Thank you for your email received 23 September 2019 seeking WaterNSW's comments on Goulburn Poultry Processing Mixed Use development (SSD 9143). WaterNSW appreciates the opportunity to provide detailed comments on this proposal.

WaterNSW has reviewed the Environmental Impact Statement prepared by KDC (dated 1 August 2019) and undertaken a site visit. WaterNSW has the following concerns regarding the water quality impacts from this application:

NOTE: SPEL STORMSACKS TO COLLECT RUNOFF FROM ALL HARDSTAND IMPERVIOUS AREAS.

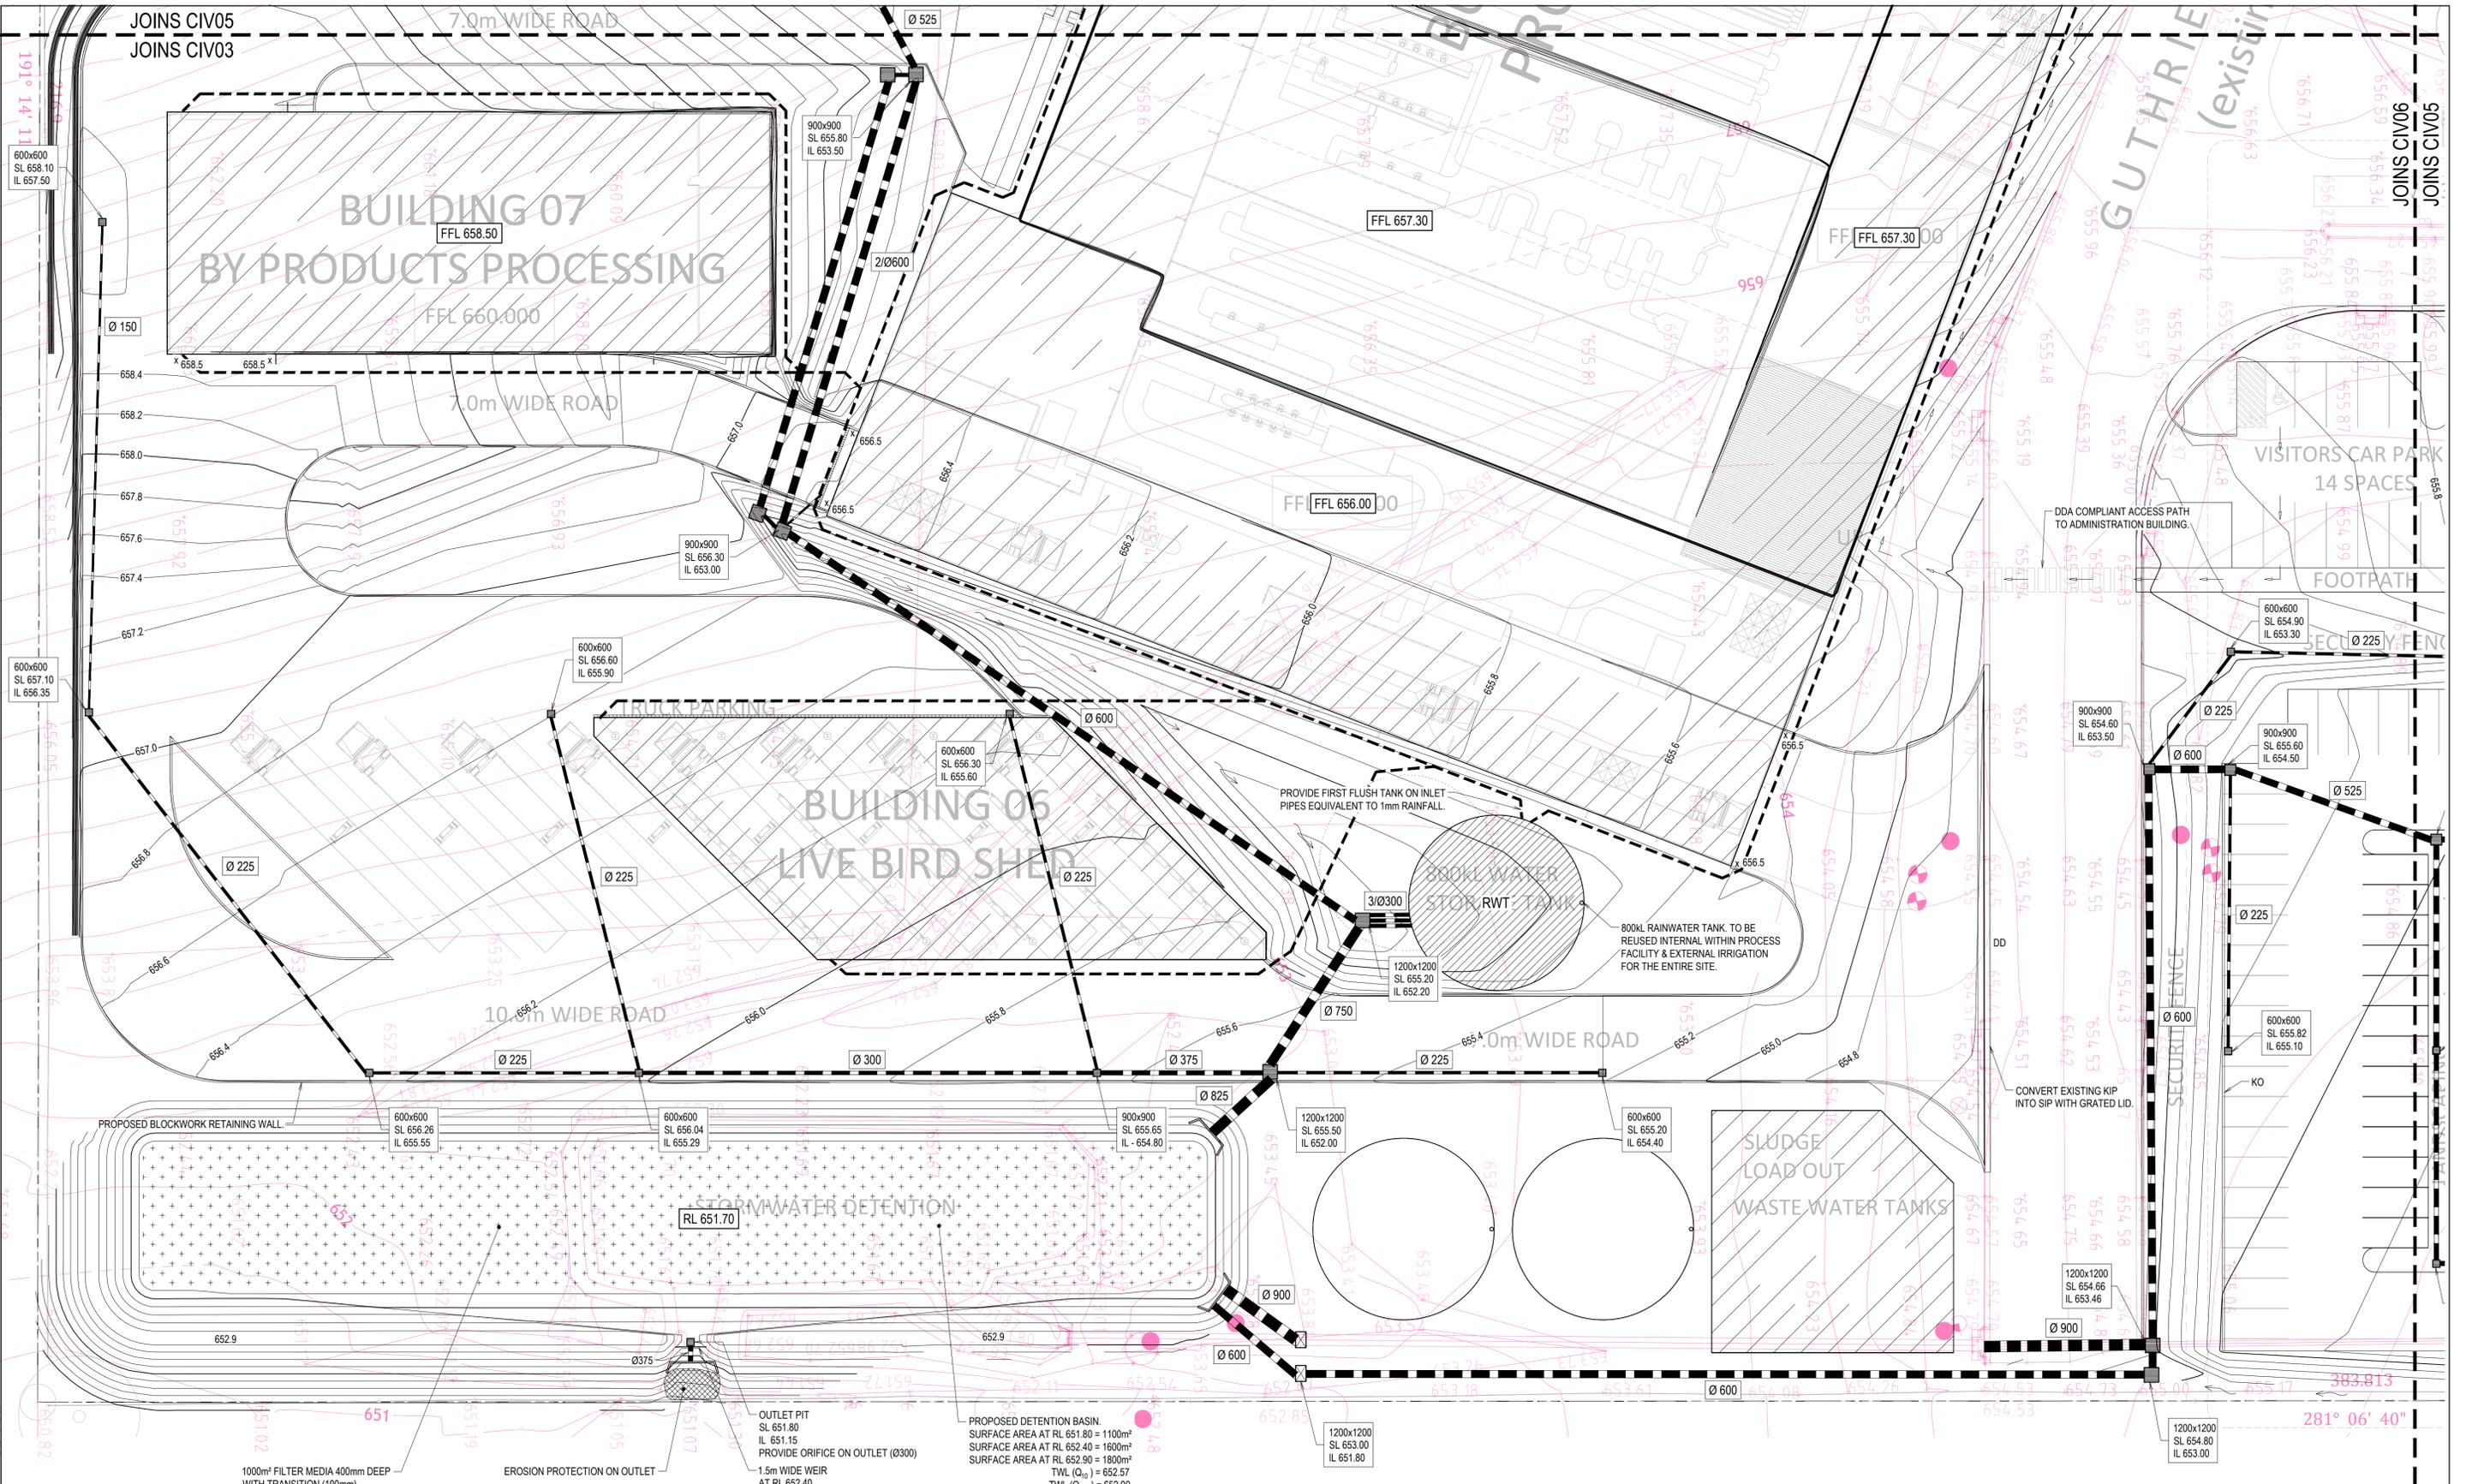
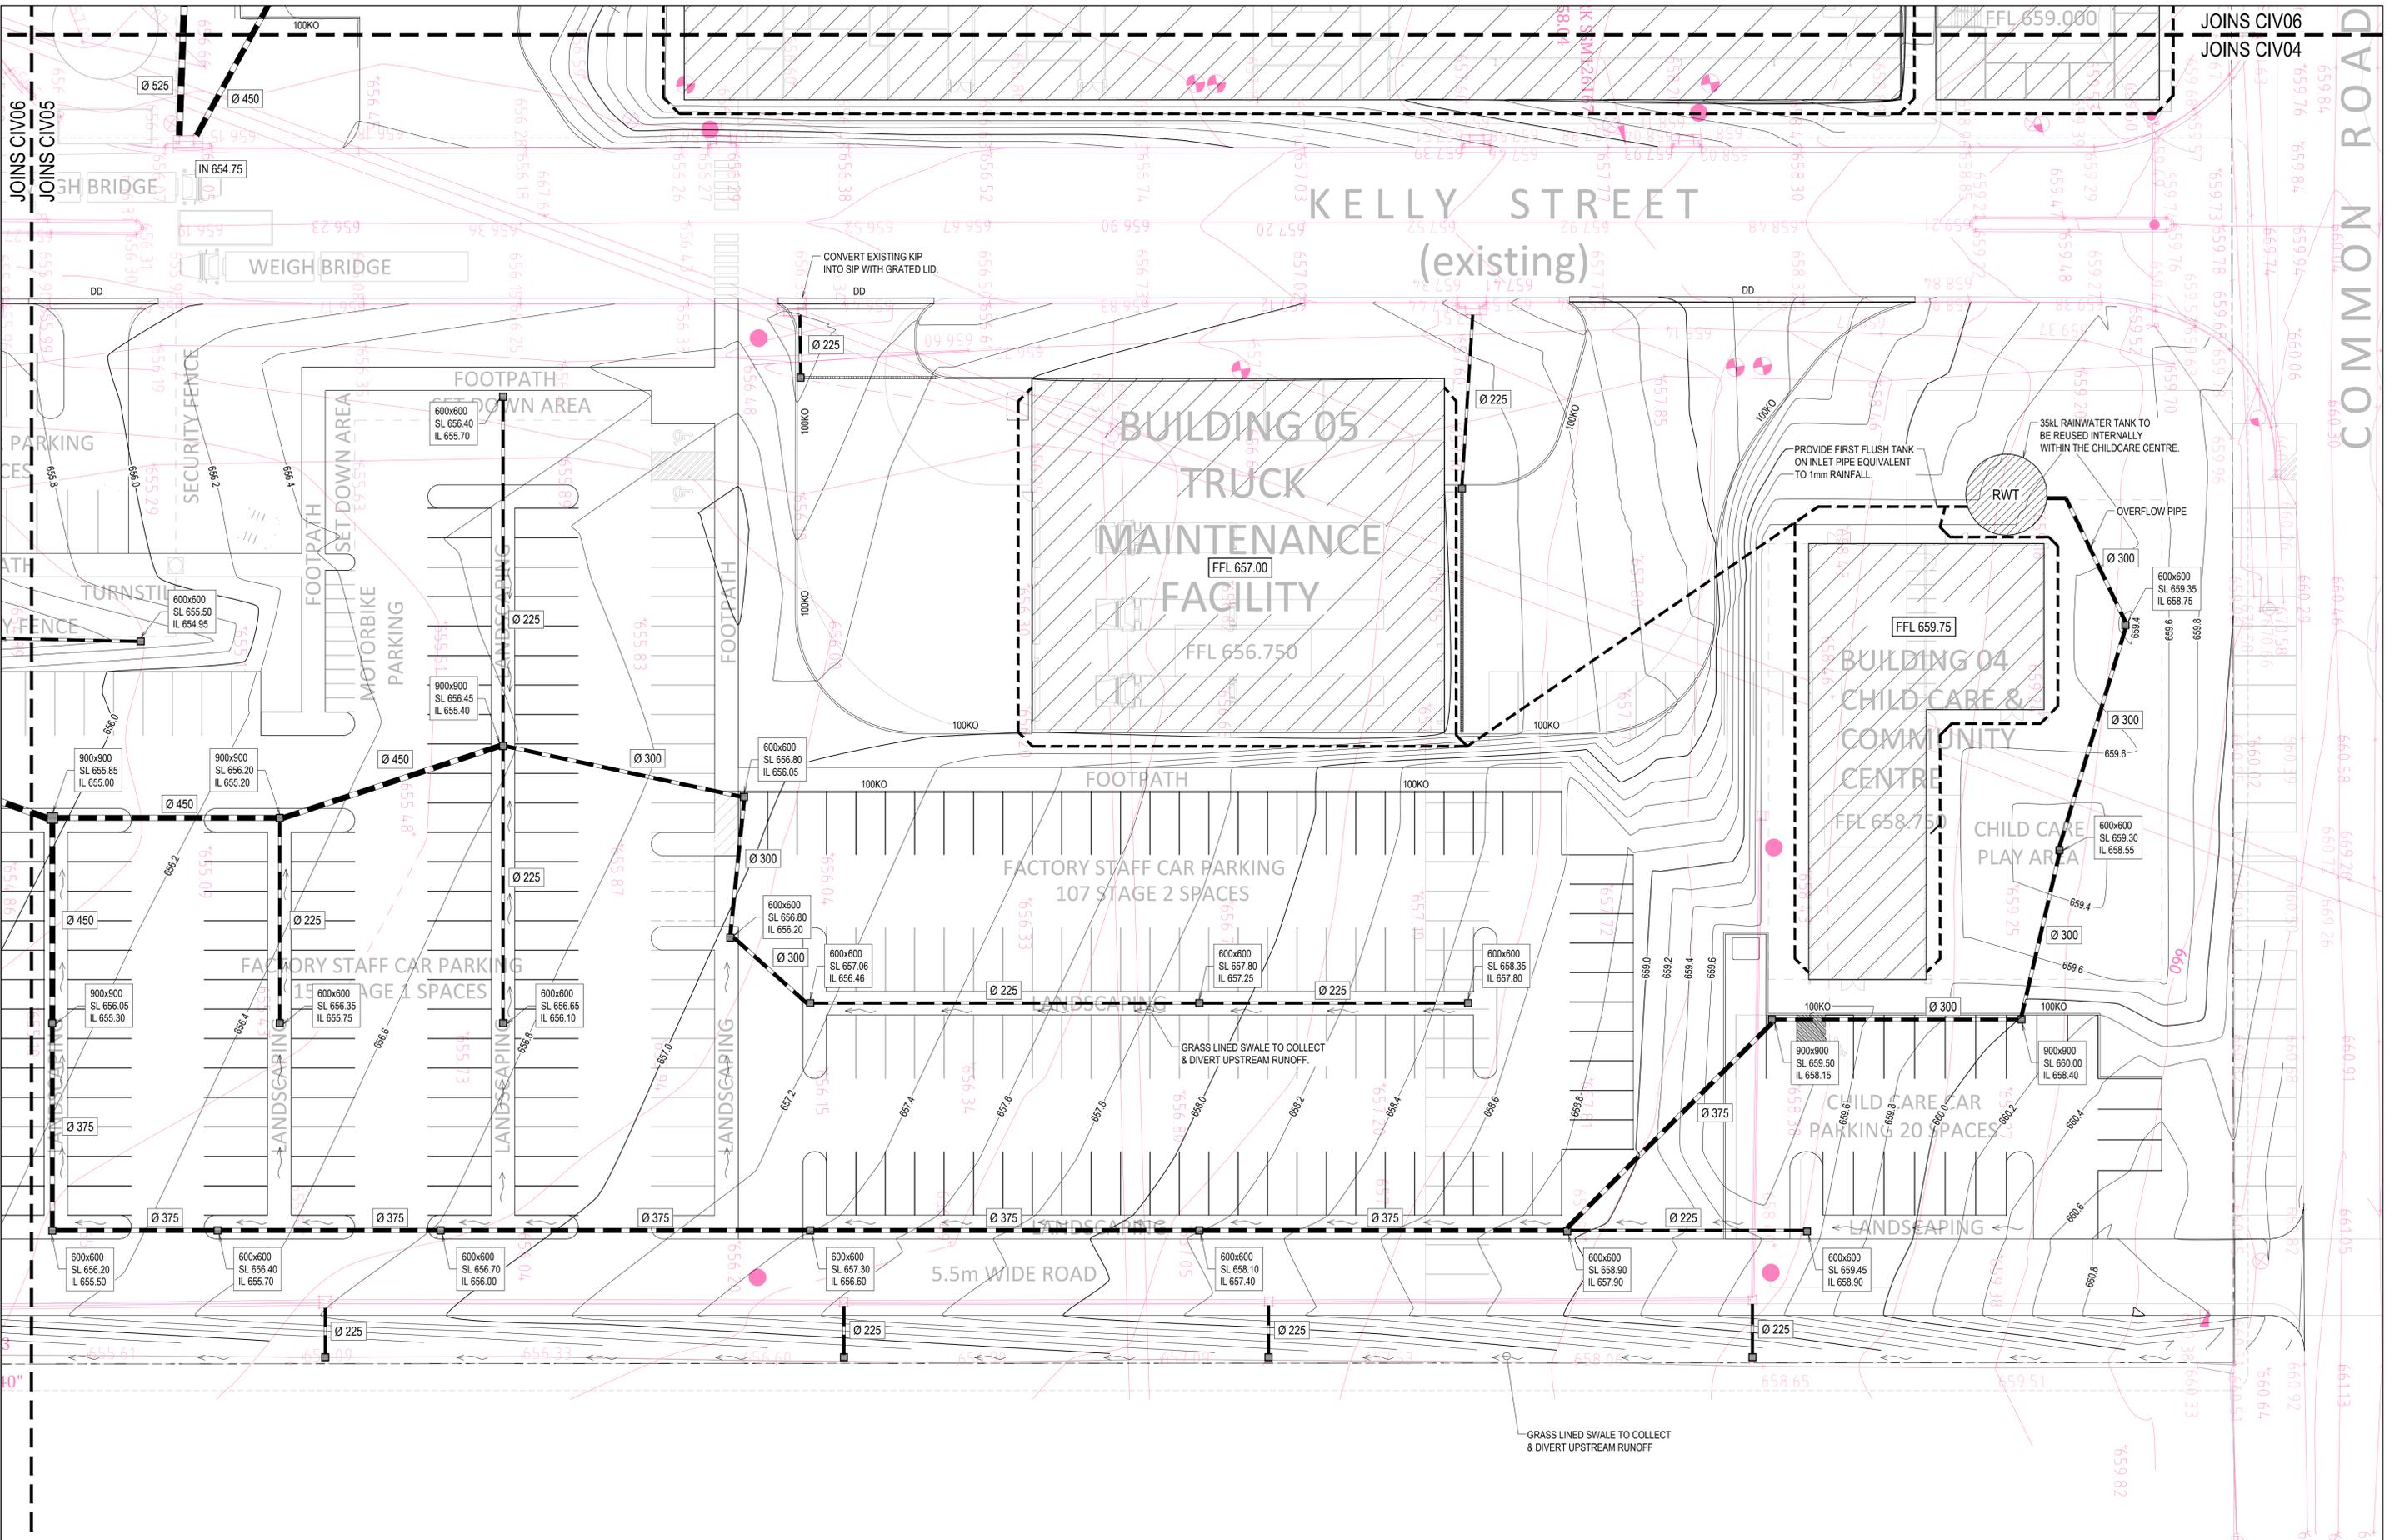
- The proposal does not incorporate all WaterNSW's Current Recommended Practices (CRPs), or demonstrate how the outcomes of those CRPs will be met, as required by Clause 9 of the SEPP (Sydney Drinking Water Catchment) 2011. In particular, Water NSW notes that:
 - Staging has not been considered in the MUSIC stormwater quality modelling or the erosion and sediment control documentation, and
 - the MUSIC stormwater quality model has not been prepared in accordance with the CRP *Using MUSIC in Sydney Drinking Water Catchment* (WaterNSW 2019).
- Consequently, it cannot be determined whether Stage 1 has a neutral or beneficial effect (NorBE) on water quality.
- Further, when WaterNSW amended the MUSIC stormwater quality model to meet the CRP requirements, the final proposal would not comply with the NorBE test on water quality.

- the quantity of wastewater that would be produced in Stage 1
- the management of washdown water from the proposed truck maintenance facility
- whether there is enough space on-site for both the proposed Moving Bed Biological Reactor (MRRB) tank and stormwater detention basin
- MUSIC stormwater quality model that meet the requirements of the relevant CRP, and
- a soil and water management plan showing how the proposed bioretention system will be protected during the construction of Stage 2 of the proposal.

- the Water Management Plan
- the Civil Works Plans, and
- the Overall Site Plan.
